Recommendation Report for Planning Permission for Works or Extension to a Dwelling

REF NO: A/12/19/HH

LOCATION: 6 Ashmore Avenue
Angmering
BN16 4GG

PROPOSAL: Conversion of detached garage loft space to become studio with rear part pitched roof dormer and external staircase with screening (Resubmission of A/116/18/HH)

PROPOSED ELEVATIONS (GARAGE) 1:100

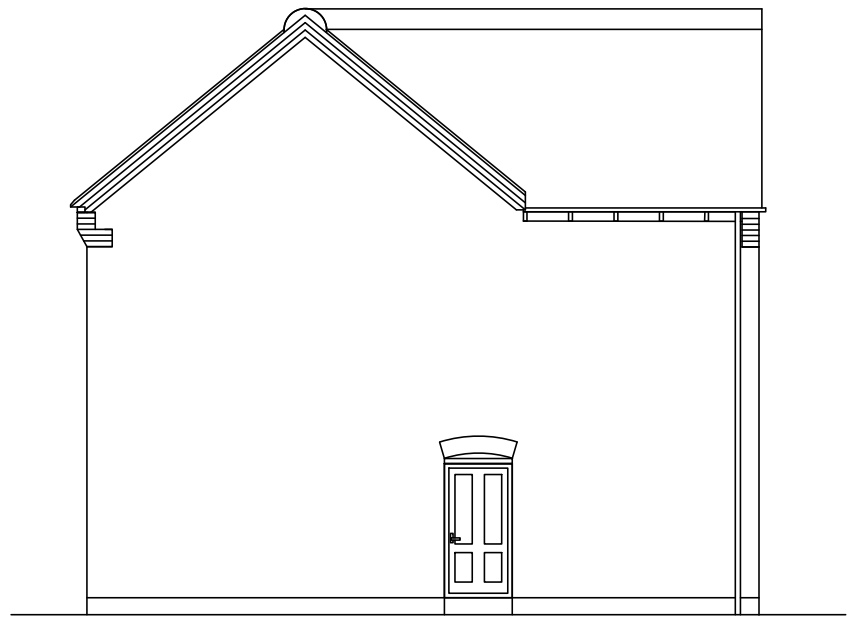
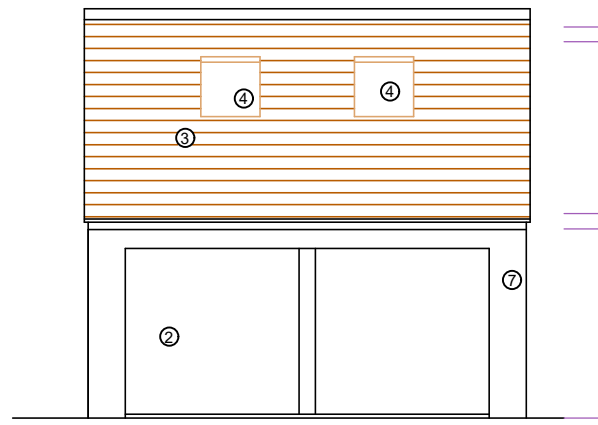
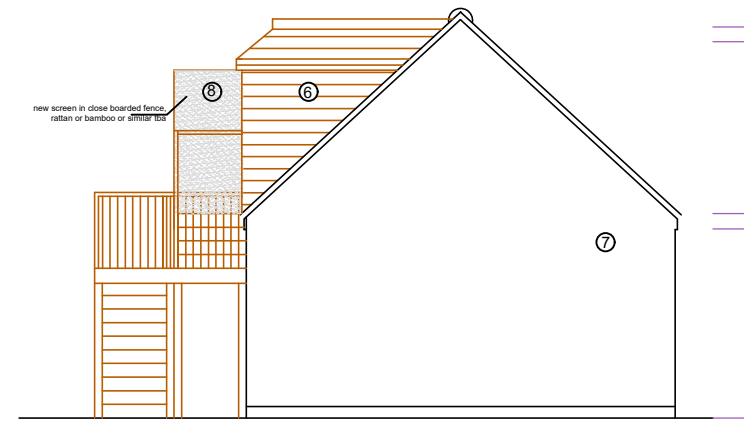
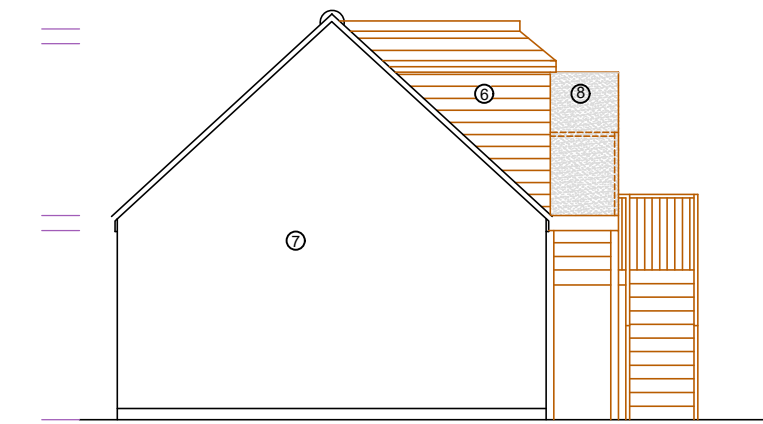
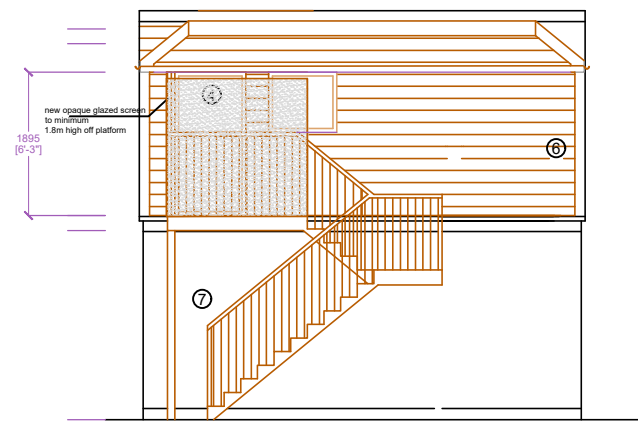
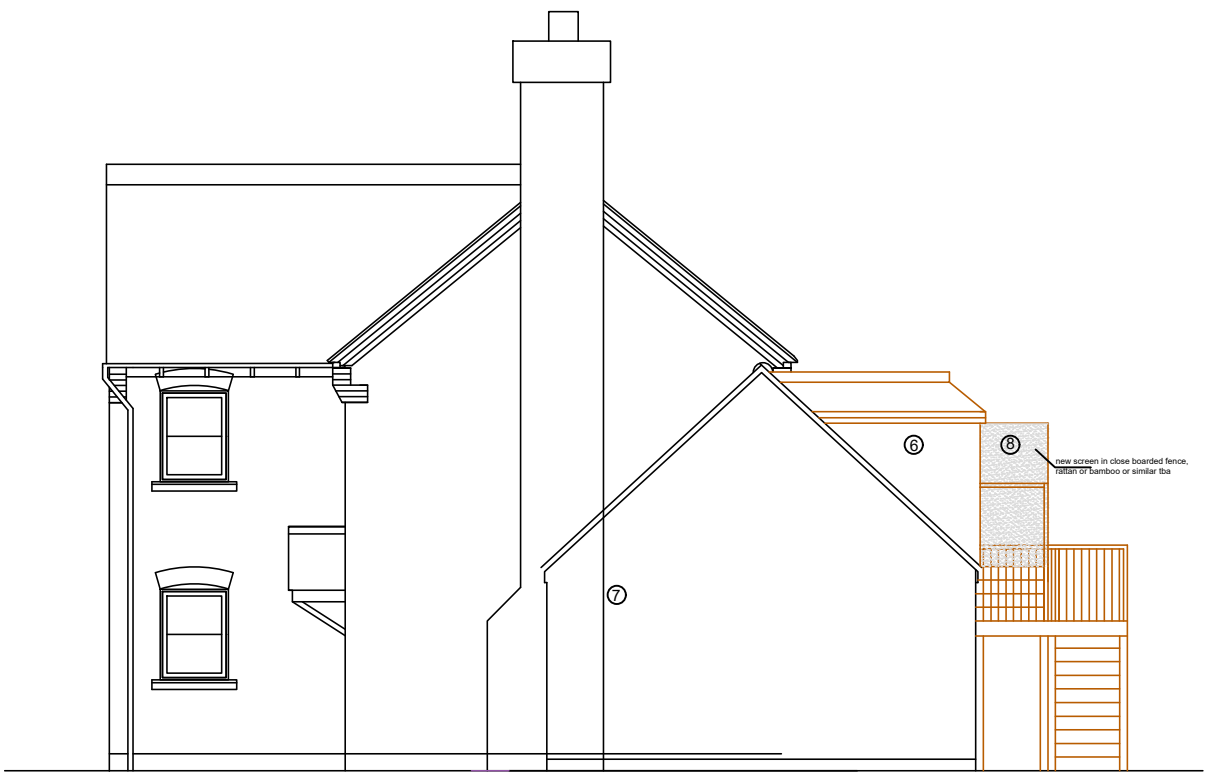
The proposed dormer is sited at the rear of the garage, and therefore is not visible from the street scene of Ashmore Avenue. However, as a result of the layout of the locality, there will be views of the dormer from Roman Avenue, and the open space to the South. Policy HD4 of the Angmering Neighbourhood Plan states that extensions that, by virtue of their materials, are clearly inharmonious with the immediate surrounding area will generally be refused. The proposed materials are to match the existing roof of the garage, and it is considered that the revised roof design allows the proposed dormer to not appear as a prominent or obtrusive feature within the locality. Policy D DM4(b) states that extensions should appear visually subservient to the main building, which, as a result of the design of the proposed dormer, this application is considered to be in accordance with. The proposed development is considered to be in accordance with D DM1, D DM4(a) and (b) of the Arun Local Plan. Additionally, Policy HD4 of the Angmering Neighbourhood Development Plan.

With regard to residential amenity, the proposed alterations will be located in close proximity to the northern boundary of the site. Given the close proximity of the proposed staircase to the boundary, there would be views from it of the rear garden of No. 4. However, it is considered that the addition of the screening at the first floor level will prevent any loss of privacy to adjacent occupiers. With regard to the stairs themselves, it is not considered that the staircase would be an area used for extended periods of time, as it acts as a means of access between the ground and first floor only. The proposed development is considered to be in accordance with D DM1(3) and D DM4(c) of the Arun Local Plan.

Reason: For the avoidance of doubt and in the interests of amenity and the environment in accordance with policy D DM1 of the Arun Local Plan.
- 3 The materials and finishes of the external walls and roof of the development hereby permitted shall match in colour and texture those of the existing dwelling.
